Application no: H01-0023-12

Description: Proposed garage/implement store (for domestic purposes) and change of use of agricultural land to residential

Location: 104 Barrier Bank
Cowbit
Spalding
Lincs
PE12 6AQ
PE12 6AQ

Amendment: Hardstanding reduced (dwg. no. 2358-11-01D)

AMENDED PLAN

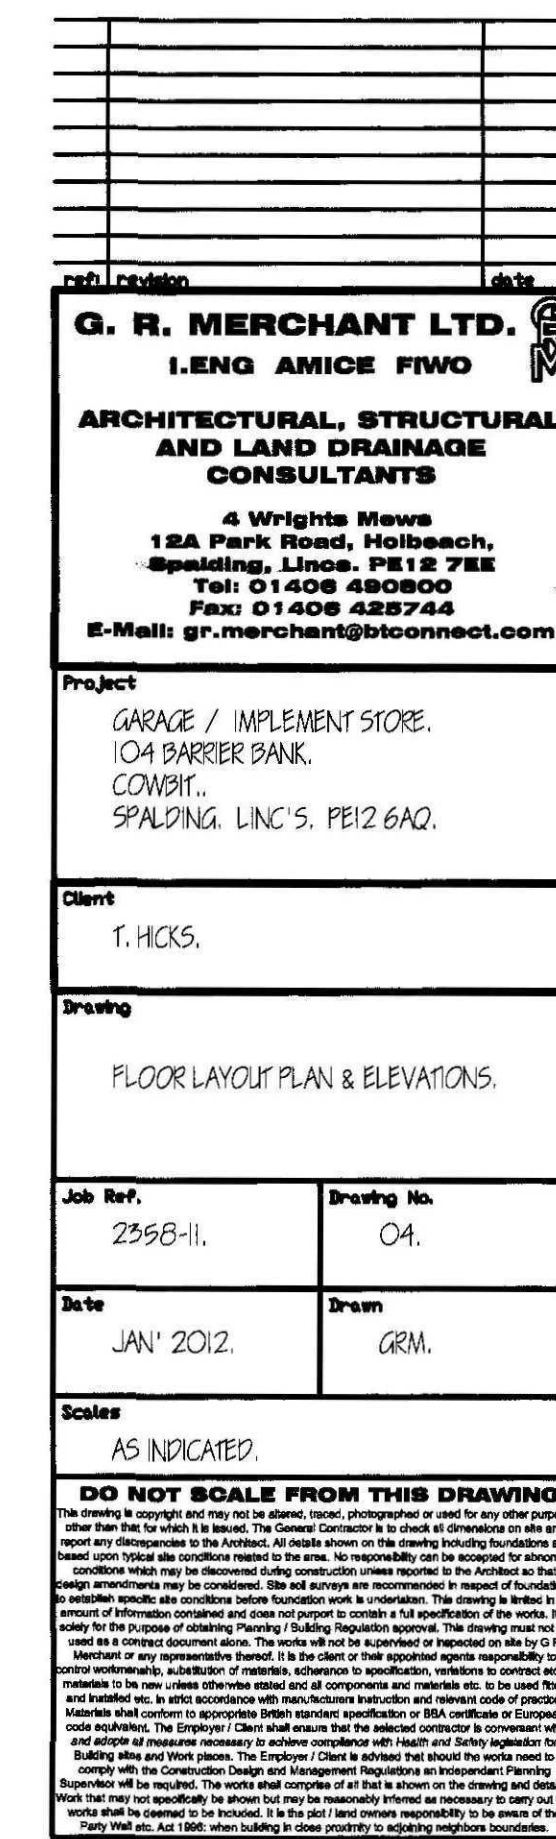
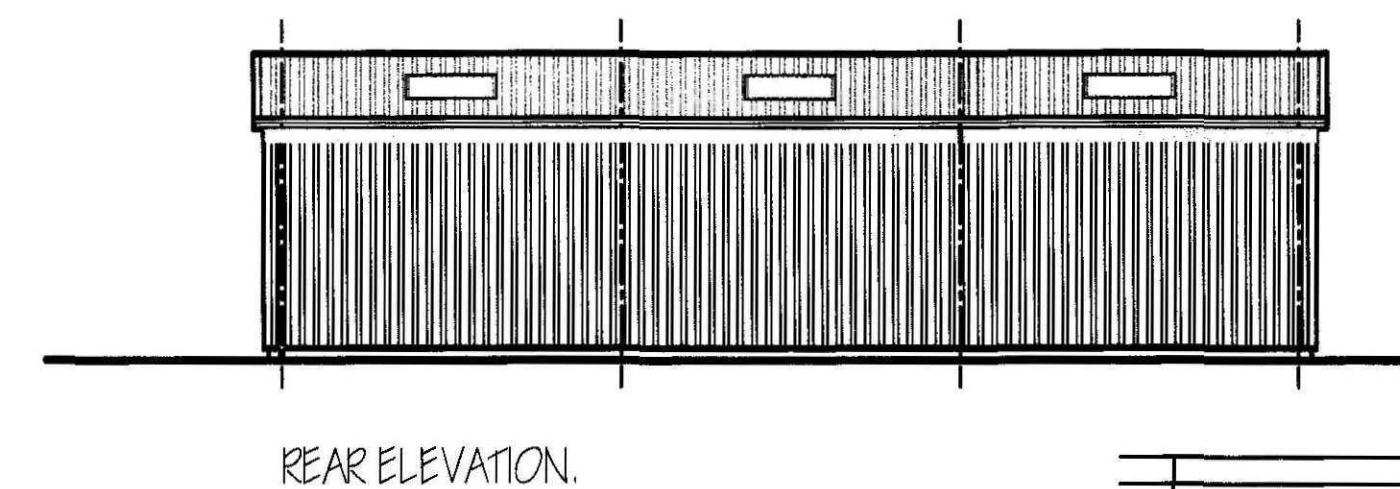
With reference to the above and your recent discussions with the office please find enclosed a copy of the amended plan showing the hard standing reduced to the proposed building. The hard standing will be removed on completion of the building and laid to grass.
